PORTLAND MAINE

March 7, 2011

Thank you for submitting an administrative authorization application for 58 Alder Street. I reviewed the application and have determined that the proposal triggers a Level I Site Alteration review under provision 14-523 (d) 2 c of the Site Plan Ordinance:

FD.1
Level 1 Site
Plan Alteration

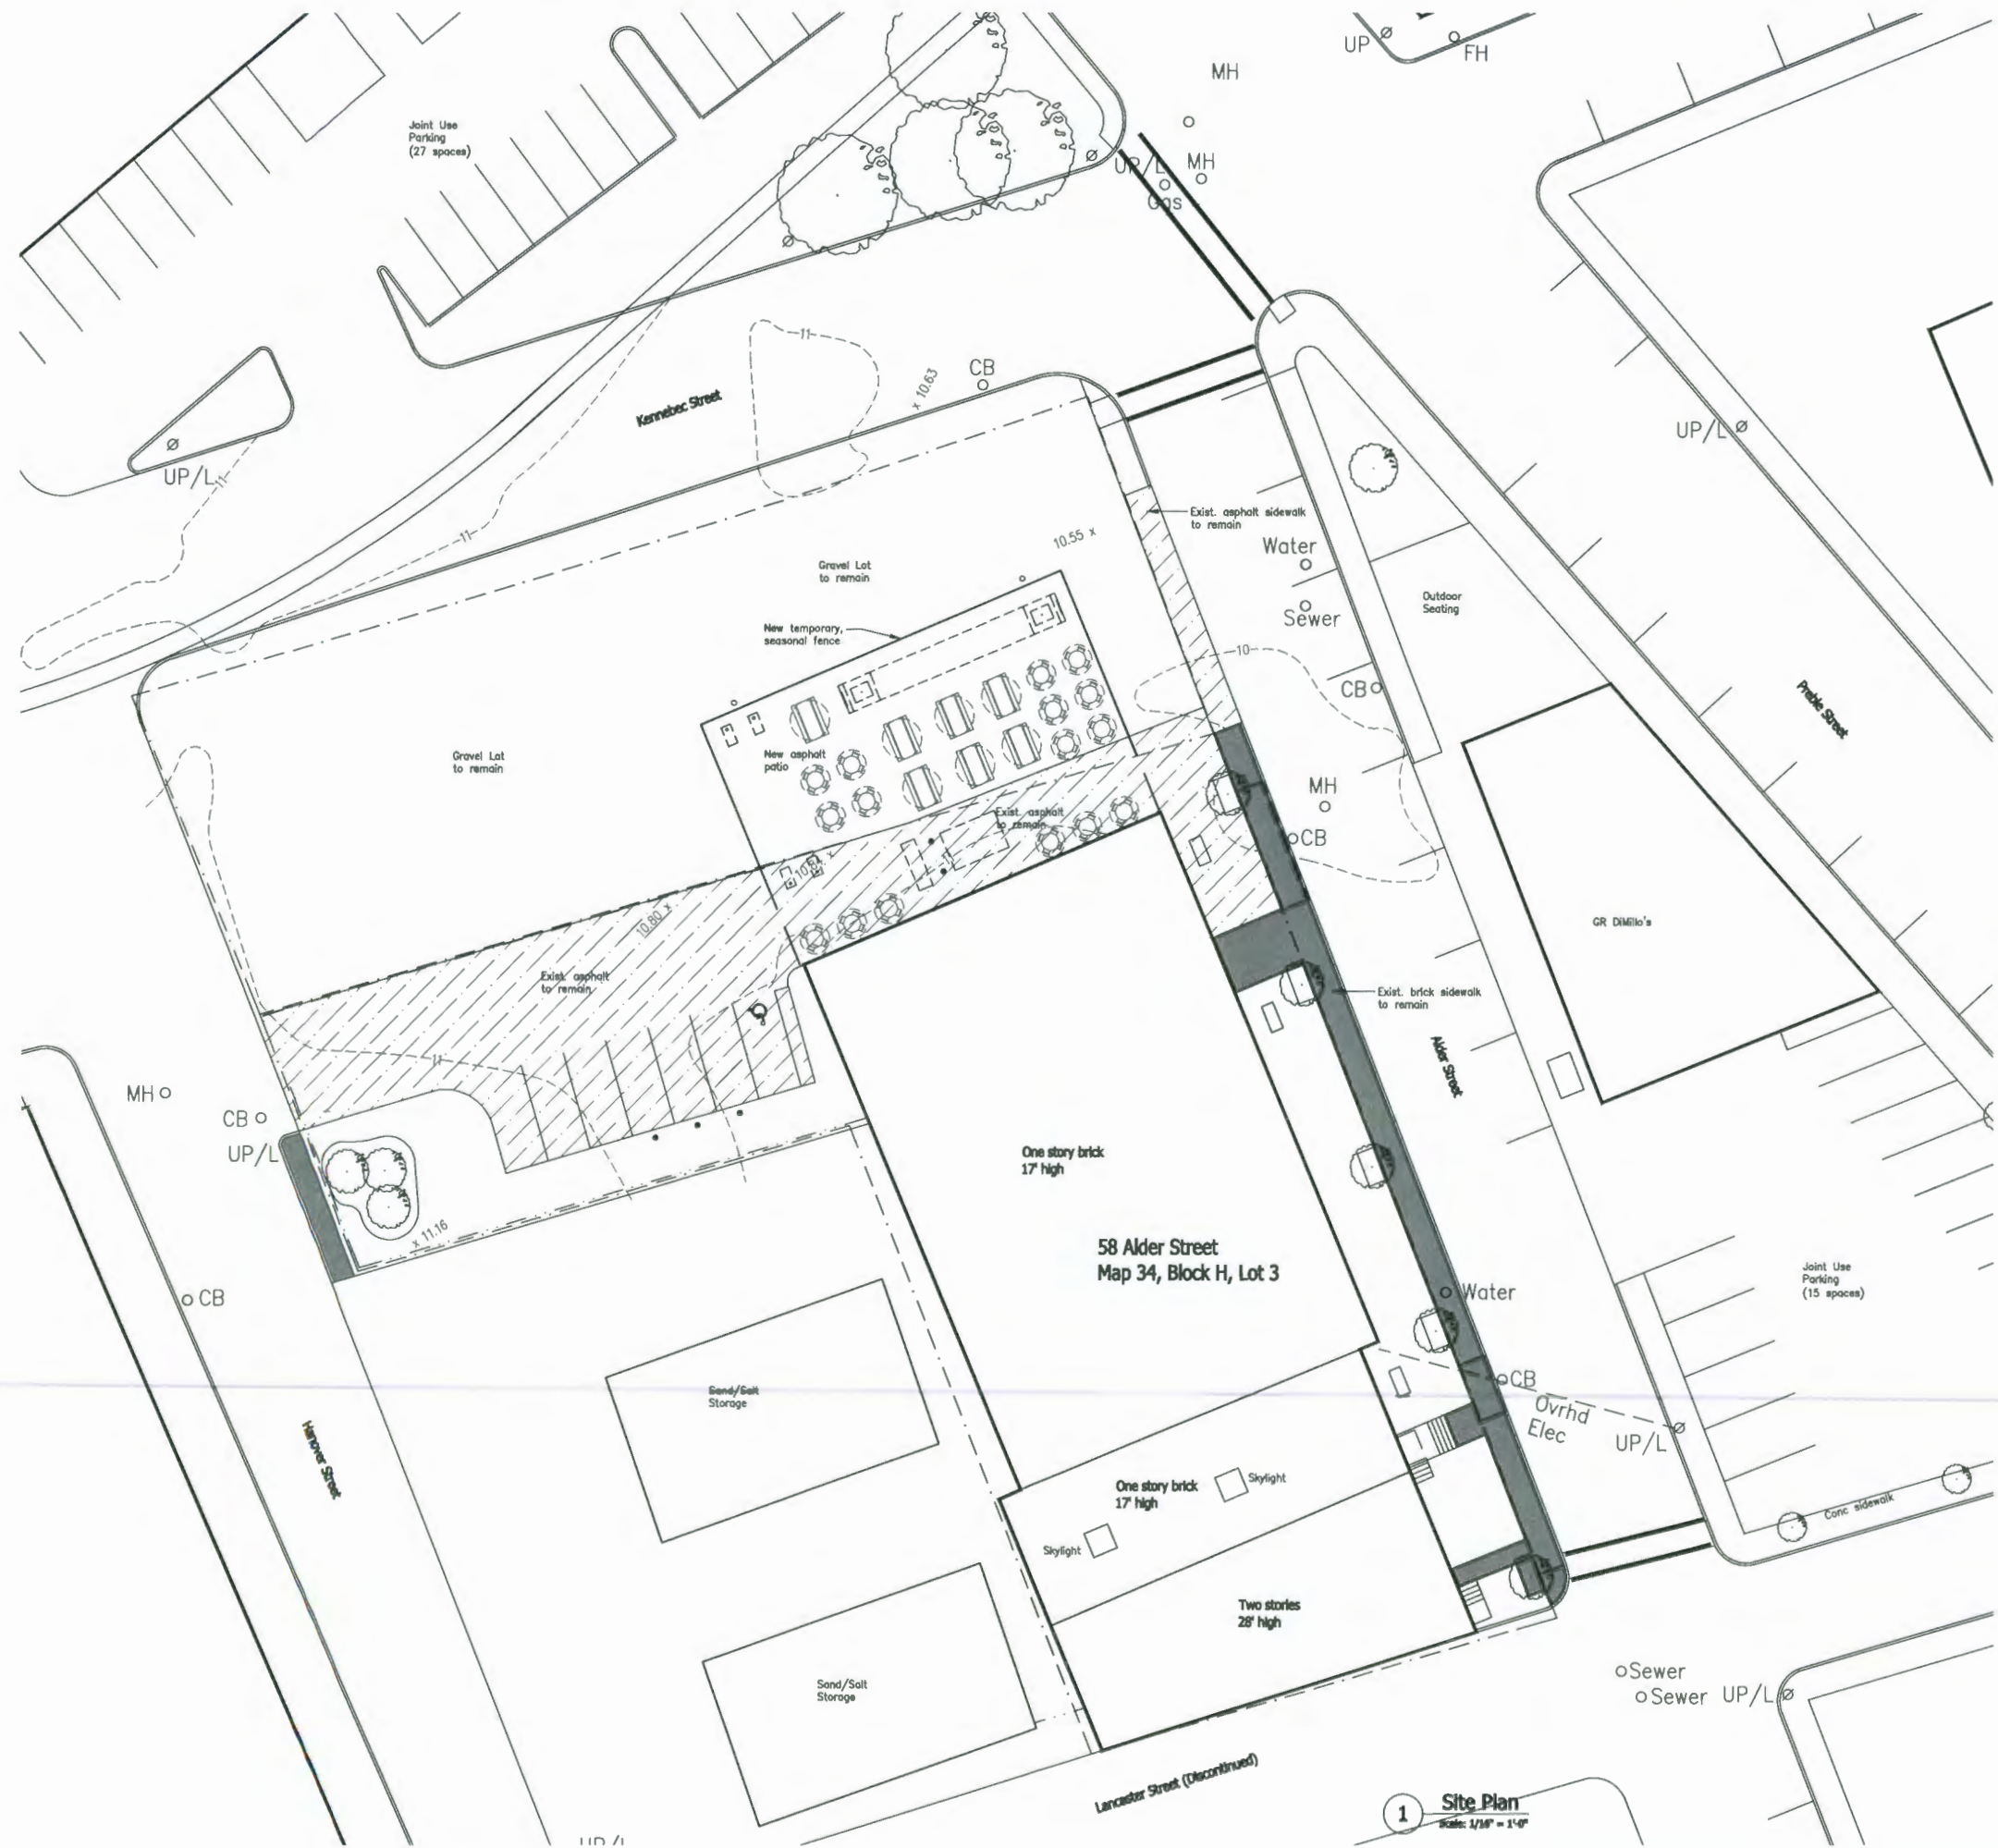
The amount of area to be paved is not shown on the site plan, but I estimate that it is roughly 2,560 square feet of impervious surface area. Enclosed please find your check for the administrative authorization, which is being returned, and a copy of the Level I application for your use.

- Evidence of Right, Title and Interest;
- Confirmation that the seating area is not a parking lot, nor will be used as a parking lot following approval as a patio area.. Please note the Planning Board is holding a public hearing on proposed amendments to the B-7 zone to allow some surface parking lots as a permitted use on Tuesday, March 8th. As drafted, the changes may not impact your proposal, but you may want to discuss the pending amendments with Rick Knowland or attend the meetings. Please let us know if you would like to be placed on our interested party list so you receive notice of when the Planning Board or City Council will be considering the B-7 amendments;
- Address closing off the curb cut with curb and sidewalk along Alder Street;
- Provide a plan for the management of storm water on the site and show the contours or spot elevations for the re-grading of the site;

- Address any proposed landscaping and the details of the fencing, including whether the fencing is permanent or temporary and any separation needed between the seating and 7 space parking area;
- An expanded project description would be helpful, such as the proposed hours of operation, proposed time frame for this seasonal use, the proposed uses for the area, including whether outside music is proposed, will food be prepared outside and where and how will the equipment be stored during off-season. (If the site will be used for off-season storage of equipment and fencing, please provide a winter conditions plan.)
- The traffic engineer will review the TDM as part of the Level I review, so there are no preliminary comments at this time.
